From: Amanda Scholes on behalf of Planning.Responses
Sent: 25 April 2019 08:29
To: Planning Scanning
Subject: FW: Windroos, Littlehampton

LU/24/19/DOC

Title
**DRAINAGE DETAIL DESIGN
SHEET 1 OF 2**

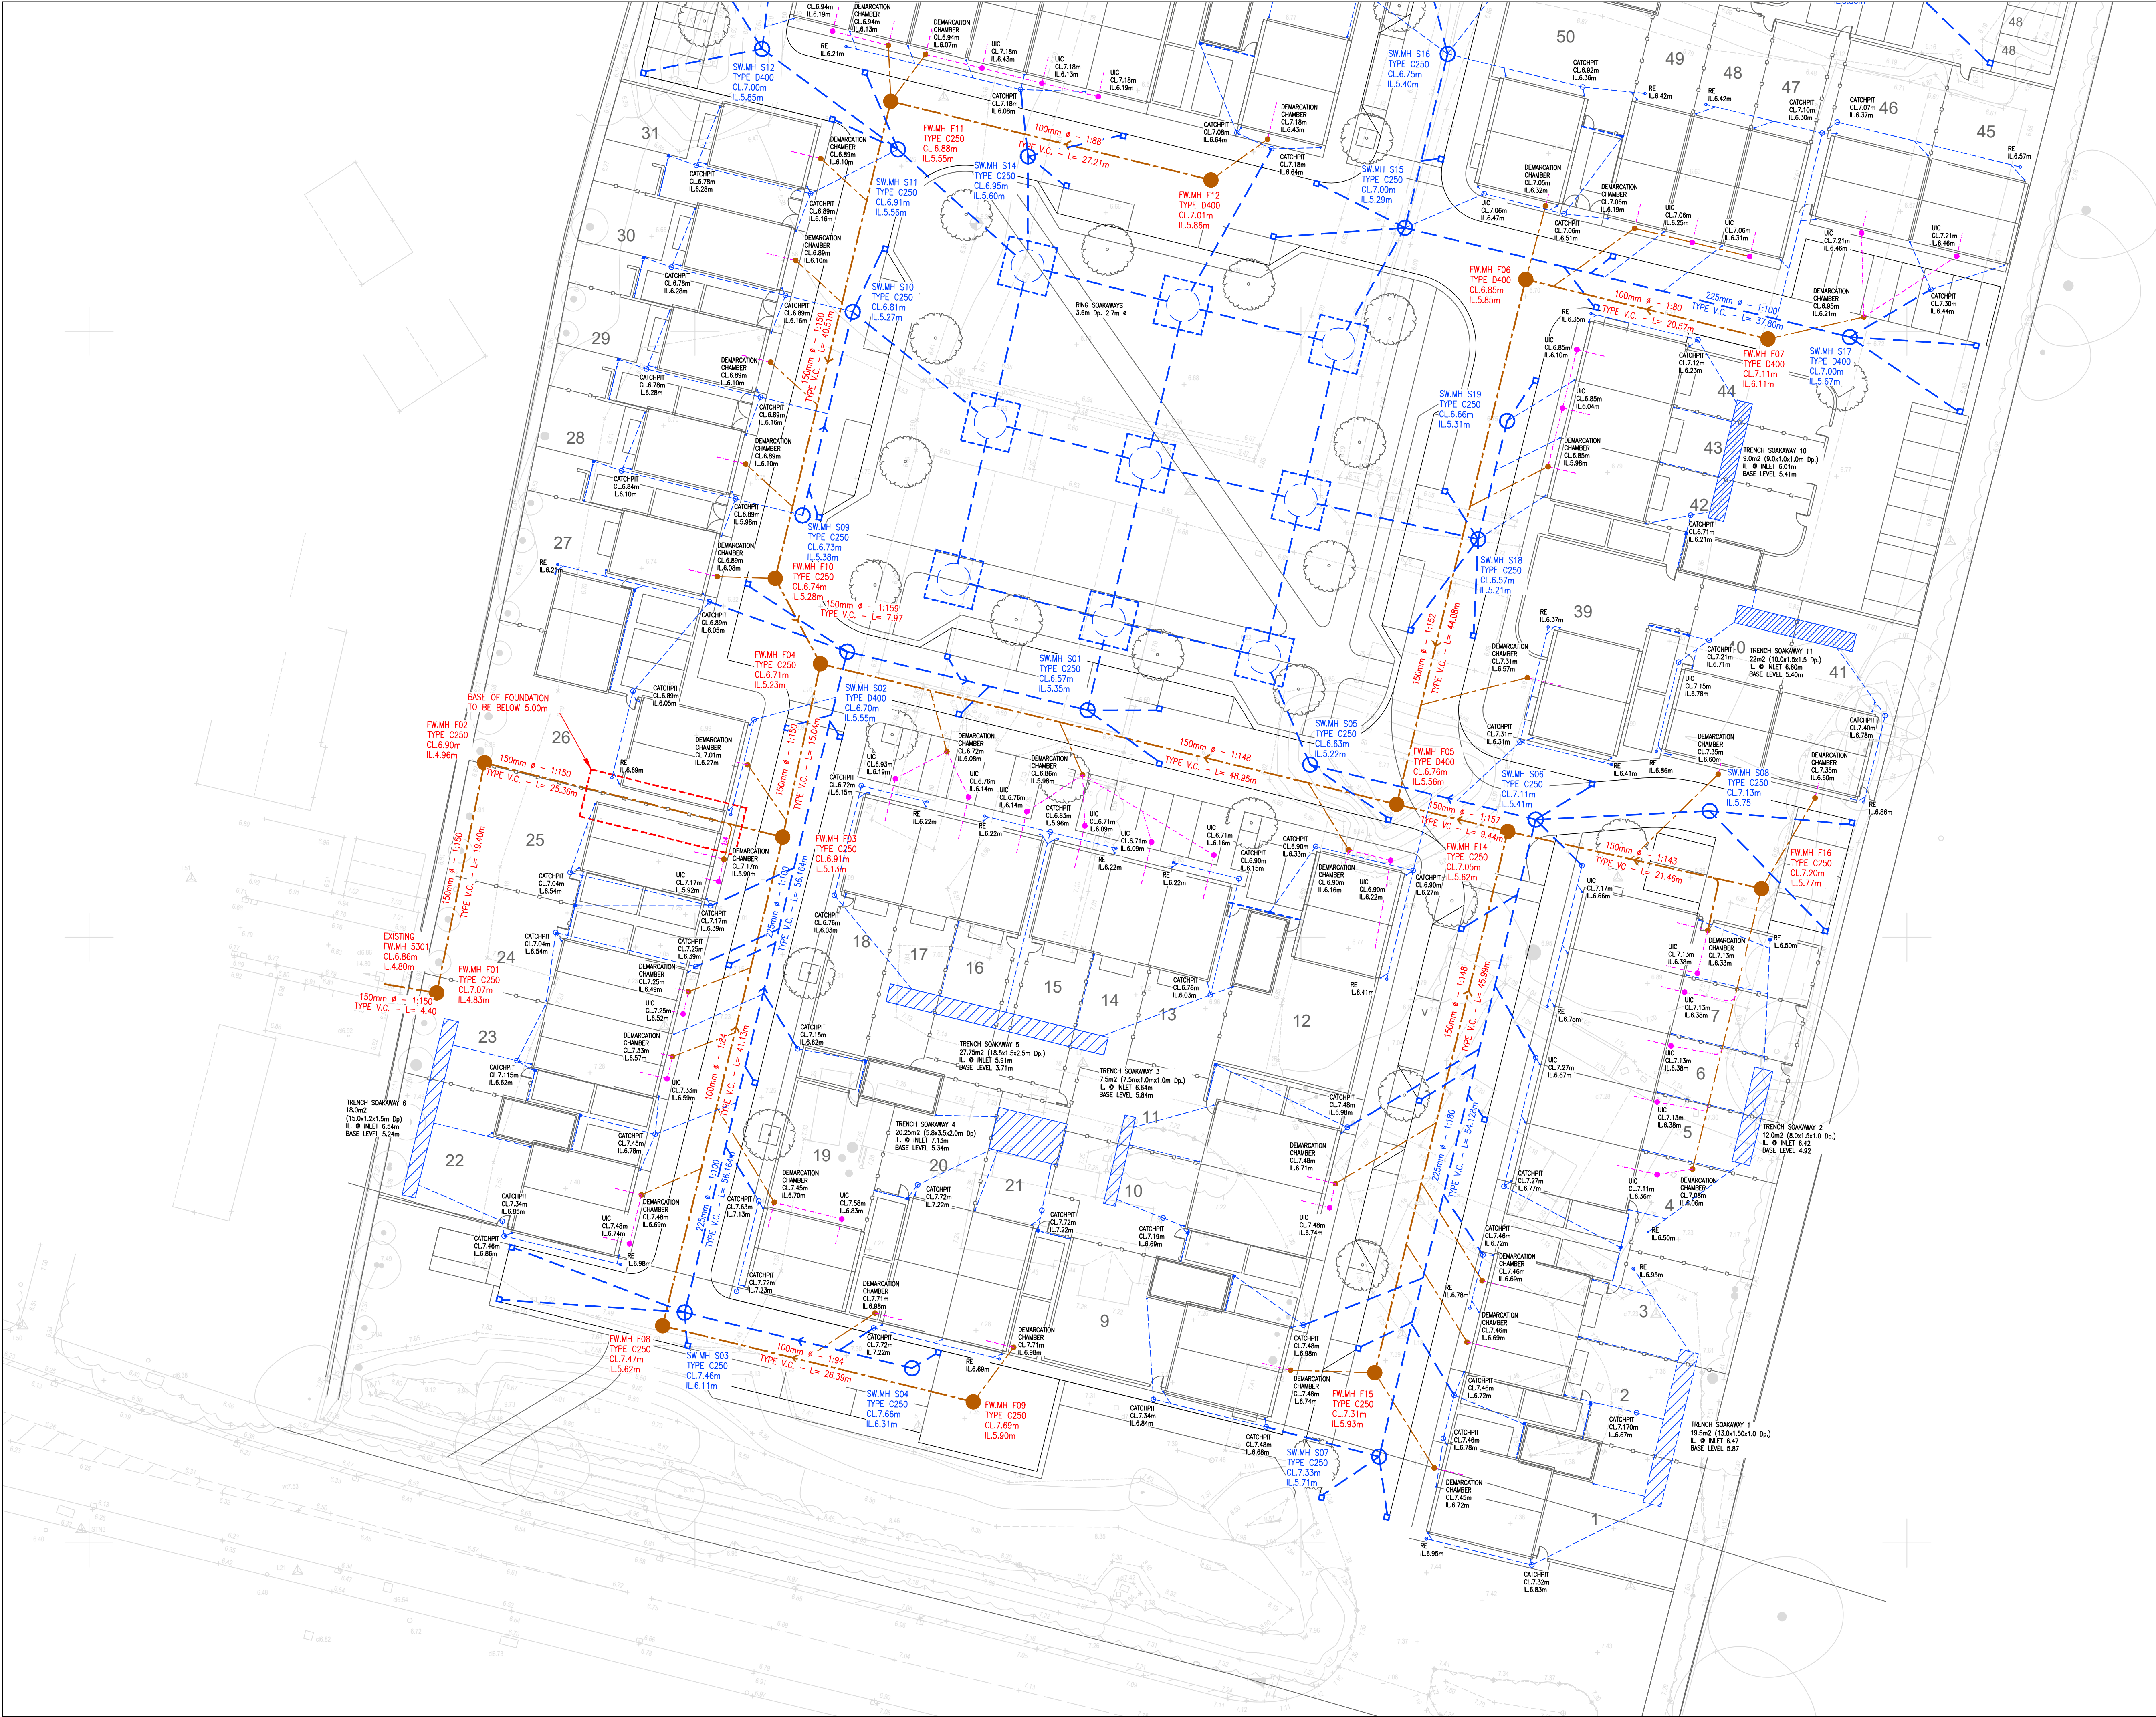
- Changing the ring soakaway size to 2.4mØ x 3.6m dp which addresses the comment from about suitability of the strata. This is adequate in terms of modelling which is also attached.
- Updating the trench soakaway references to have specific numbering which tie in with the attached modelling outputs from Microdrainage for them

4. A catchment area plan should be provided. A catchment area plan is not included in the checklist, as this is a detailed design the pipe layout shows where all the surface water is being channelled to, a catchment plan would provide no additional information on top of this. *I do not understand how this is difficult to produce and provide as you should have been using it in design anyway. It is common place for us to ask for a catchment area plan on larger developments, they expedite our review. Please provide this.*

5. One of the sets of calculations provided does not seem to equate to anything proposed on paper. I.e. the modelled dimensions are not reflected on plan. All the calcs had a reference against the design but hopefully the provision of all of the gravel trench soakaways clears this up. *Please ensure that all calculation dimensions match up with those shown on plan. There are inconsistencies in:*
Northern soakaway
Trench soakaway 1
Trench soakaway 3
Trench soakaway 4

Trench soakaway 5

Trench soakaway 6

Trench soakaway 8

Trench soakaway 9

Trench soakaway 10 -Please also provide 1 in 10 year plus cc event half drain time results.

Trench soakaway 11

Please also ensure that modelled cover and invert levels match with those shown on plan.

6. The ring soakaways are proposed to be located at 2m depth, yet rely on infiltration testing completed at 4.2m depth. The strata at these depths differs significantly. Again I stress the importance of completing winter infiltration testing at the proposed depth and location of infiltrating structures. We have provided a calculation for the specification of a ring soakaways at 3.6m depth with a 2.4m diameter, which is in the appropriate strata. The latter part of this point relates to the responses to points 1 and 2.
